File No: R/2017/17/A  
Our Ref: 2017/591424

### **SSD 8671 - Walsh Bay Arts and Cultural Precinct**

I refer to your invitation to comment on SSD 8671 for works to Wharf 4/5, Wharf 4/5 Shore Sheds and Pier 2/3 at Walsh Bay Arts and Cultural Precinct at 13 Hickson Road, Dawes Point. It is understood that the application seeks approval for internal and external alterations across the site for cultural uses and events including three new commercial spaces, wayfinding and signage and early construction works.

FIGURE 19 HICKSON ROAD ELEVATION EXISTING AT PIER 2/3

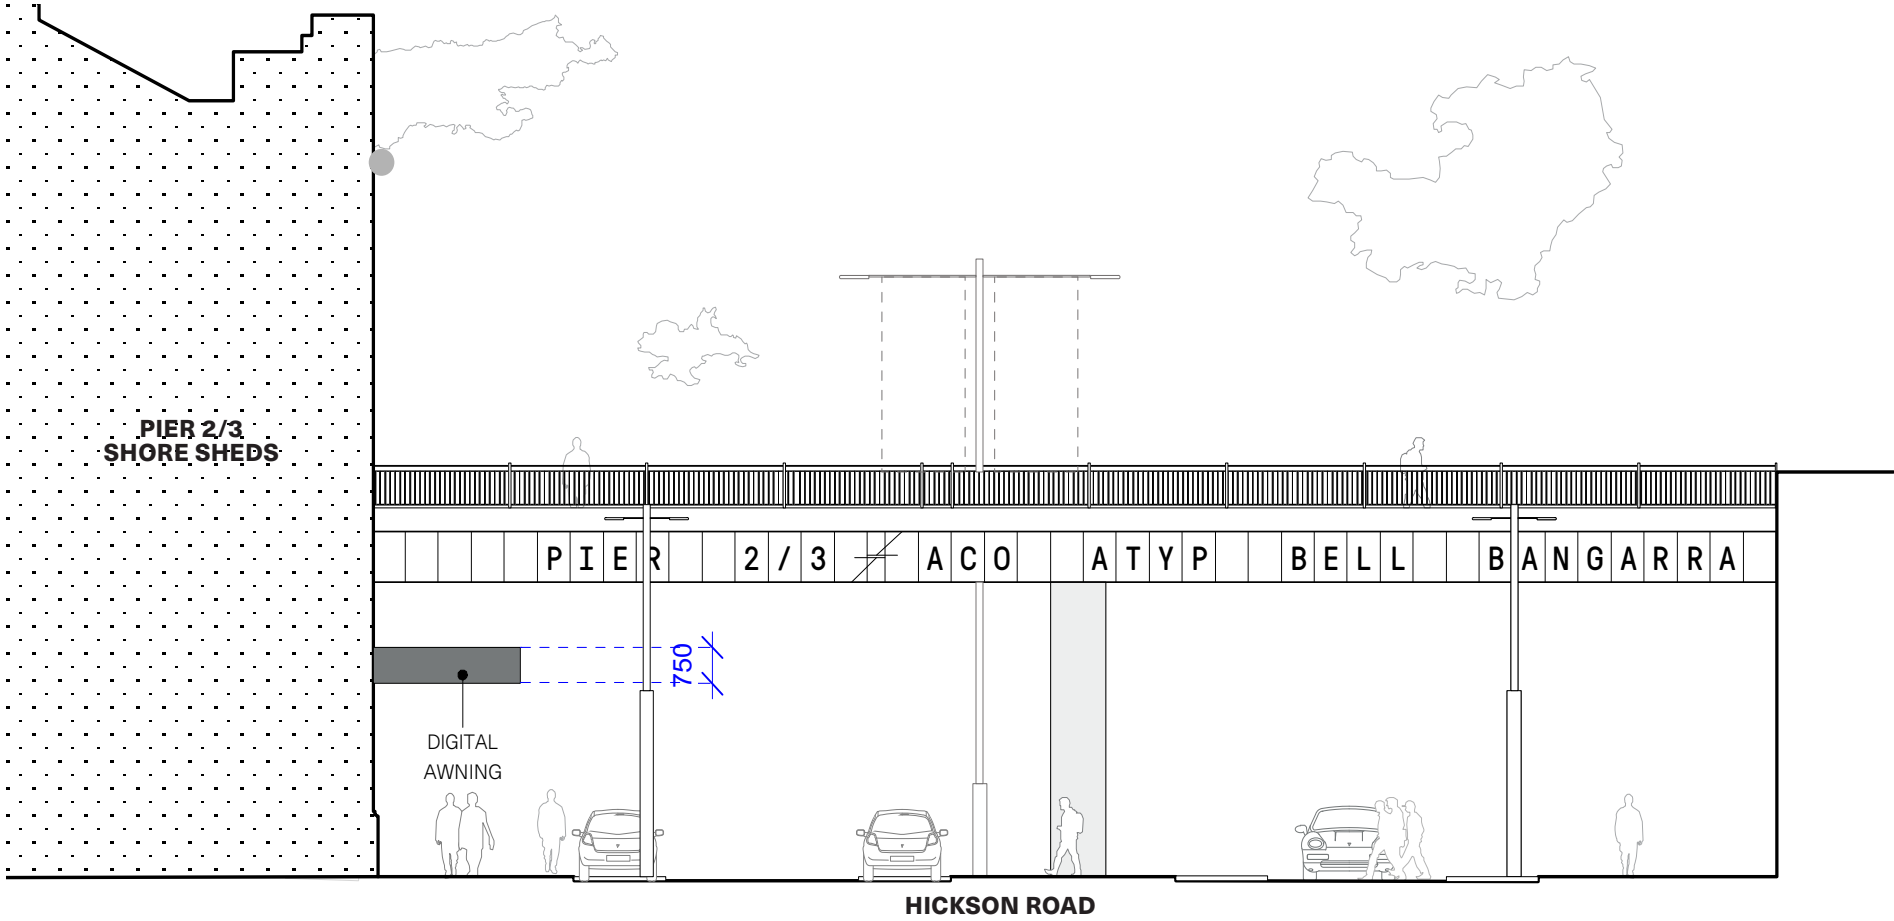
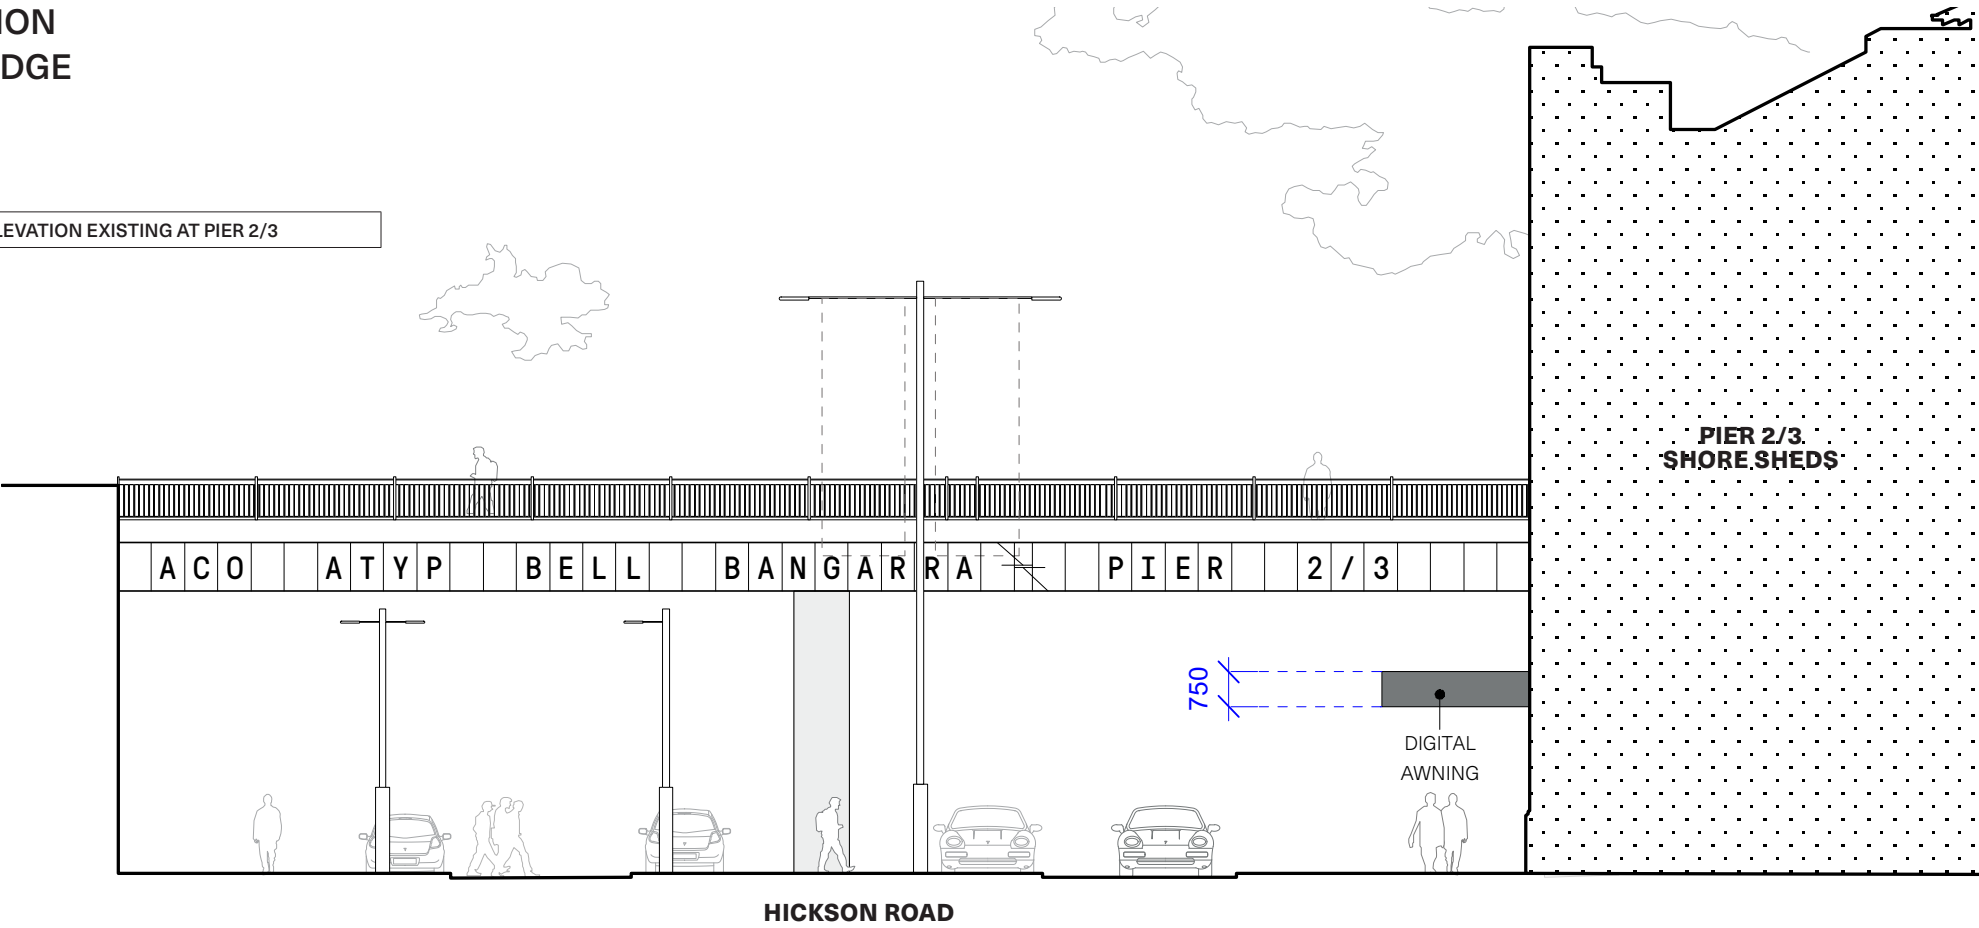
- The proposed digital awning signs as shown in Figures 12 and 13 indicate they have a minimal projection however, Figures 19 and 20 show them as substantial projecting awnings, though dimensions are not annotated. The awnings should be sized to allow a margin around them, enabling a reading of the rendered surface on which they are affixed. They should be set in from each side by approximately 200mm for the same reason.

- Figures 19 and 20 illustrate signage across the viaduct bridges akin to “The Goods Line” signage. This is supported for the ‘Pier 2/3’ and ‘Wharf 4/5’ signs as these are *place based* signs, as is The Goods Line sign. There is some concern that the other proposed bridge signs are for dance/theatre companies that may come and go to the precinct. The signage strategy should speak to the removal / replacement of these signs. The signage is designed for the present number of companies, with particular name lengths. Removal of parts of the sign over time due to the loss of a company should be addressed.

FIGURE 27 STATUTORY SIGNAGE LOCATIONS

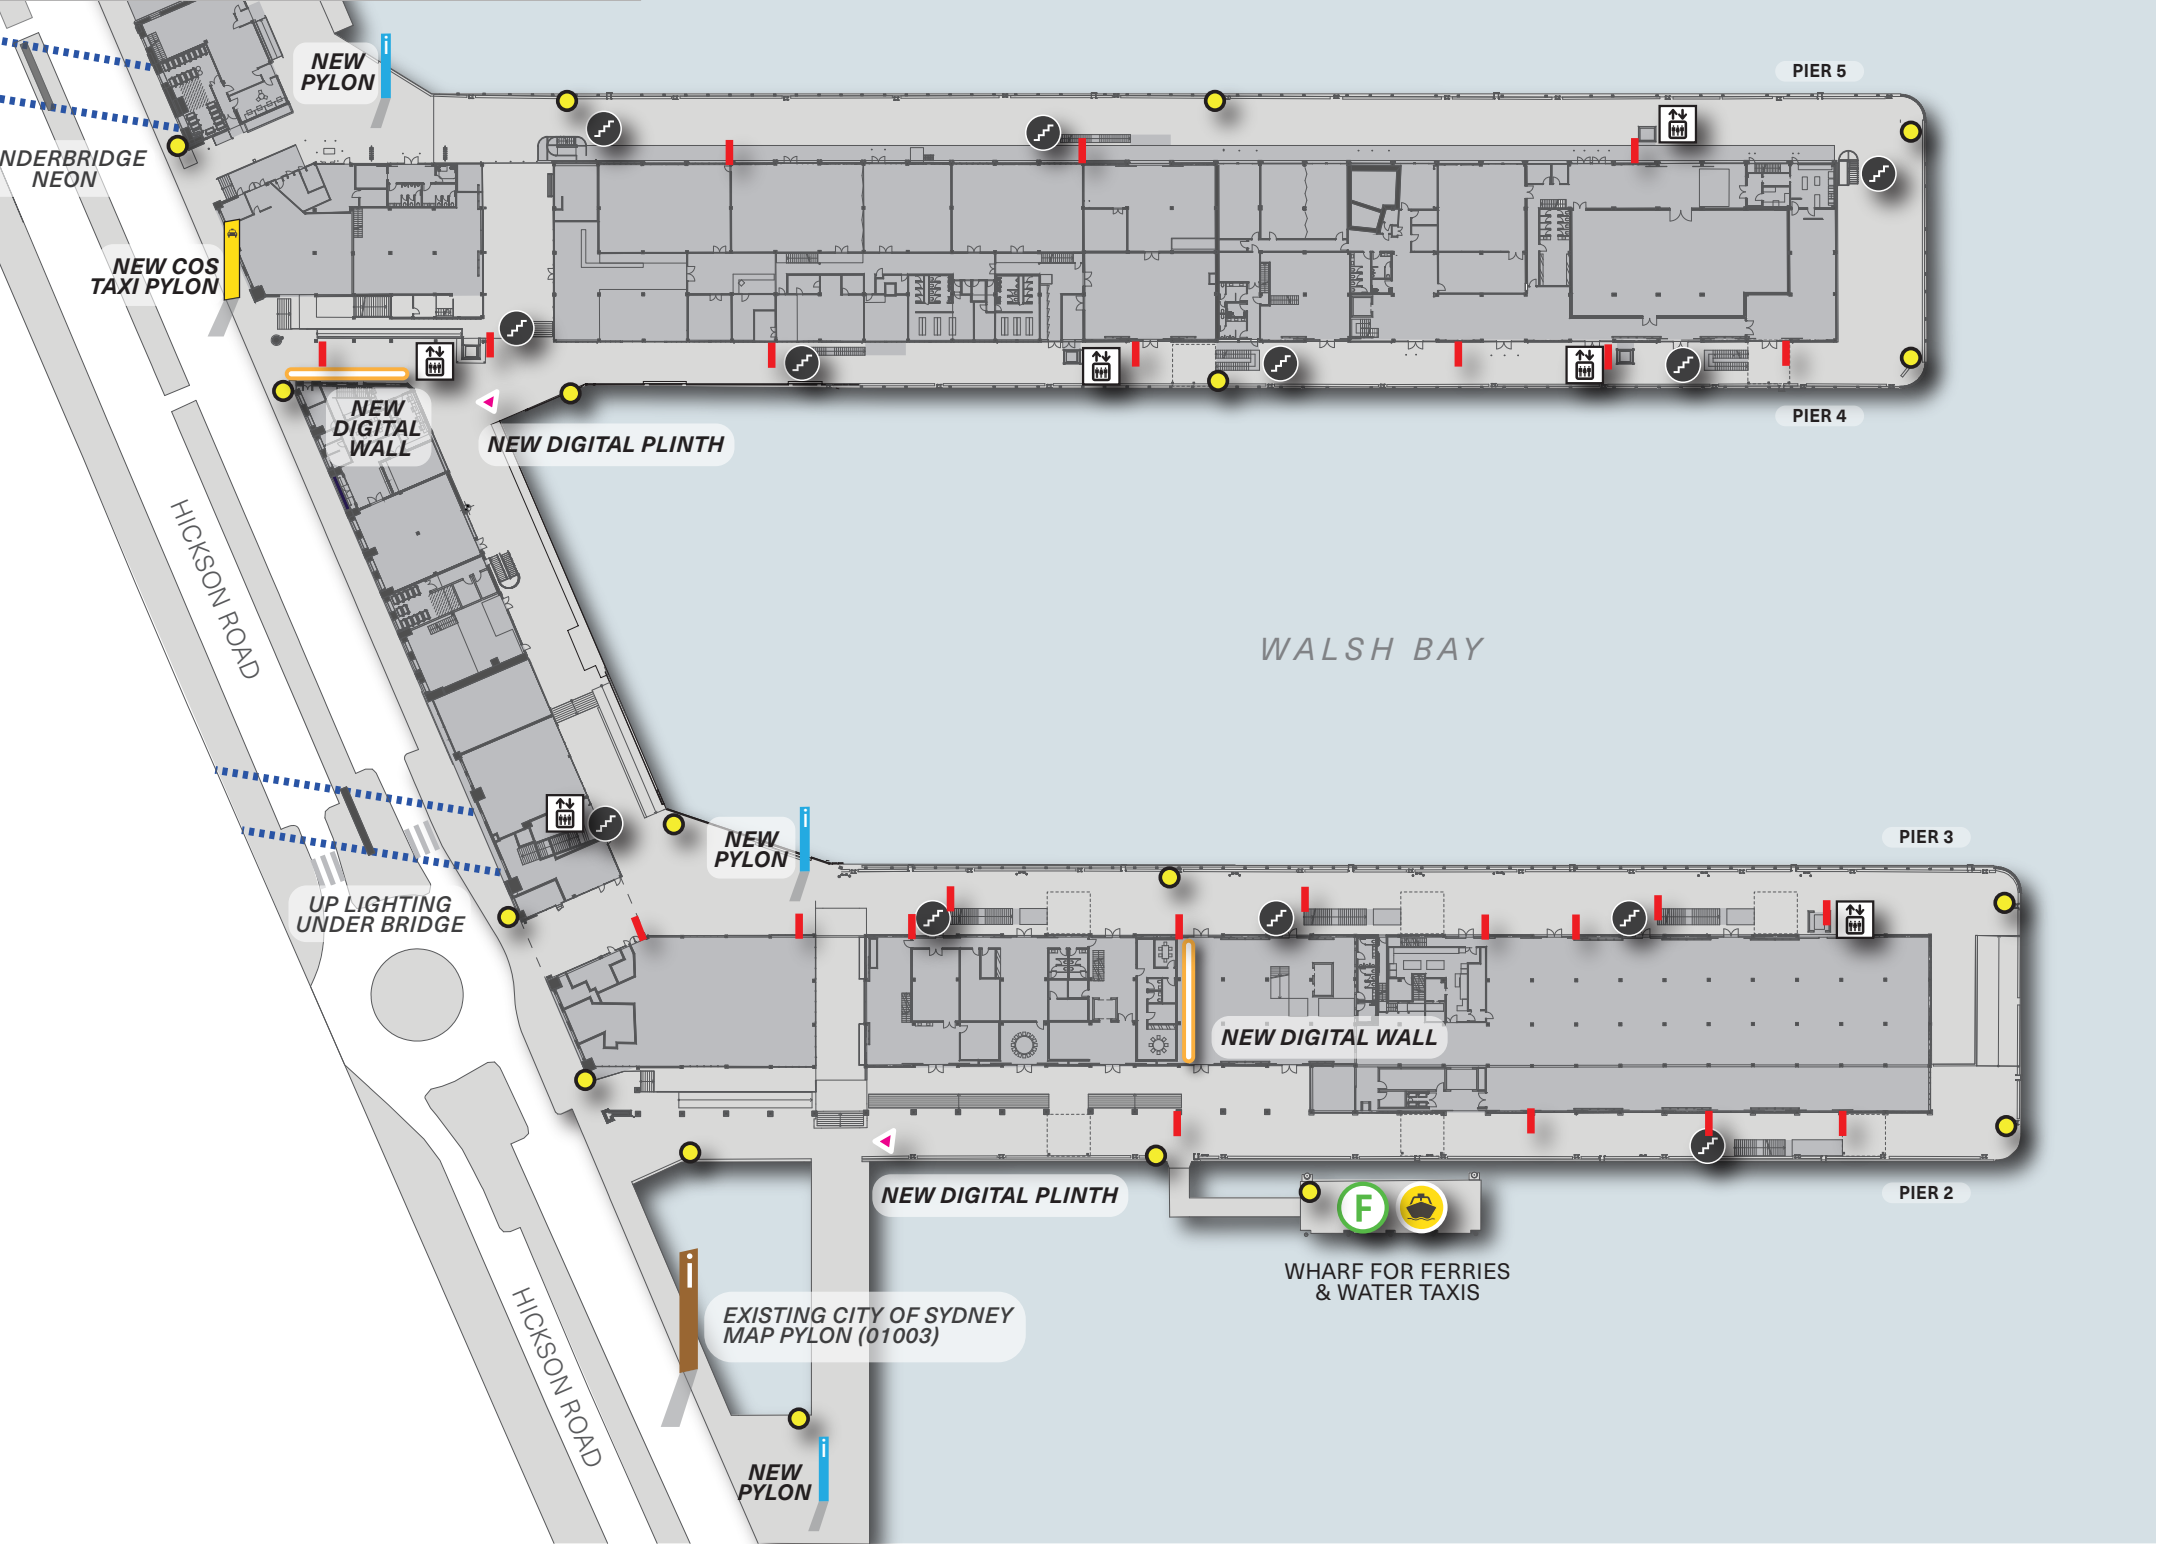
- Details of the new proposed signs shown in Figure 27 (red lines marked as "signage location") are unclear. There are a substantial number of these signs and there is a potential for clutter depending on the purpose, size, design and location of these signs.

- No details of the 'new digital walls' included in Figure 27 are provided. Details such as the size of these elements as well as their fixings to the wharf building fabric are required. Fixings should avoid significant heritage fabric and be reversible.
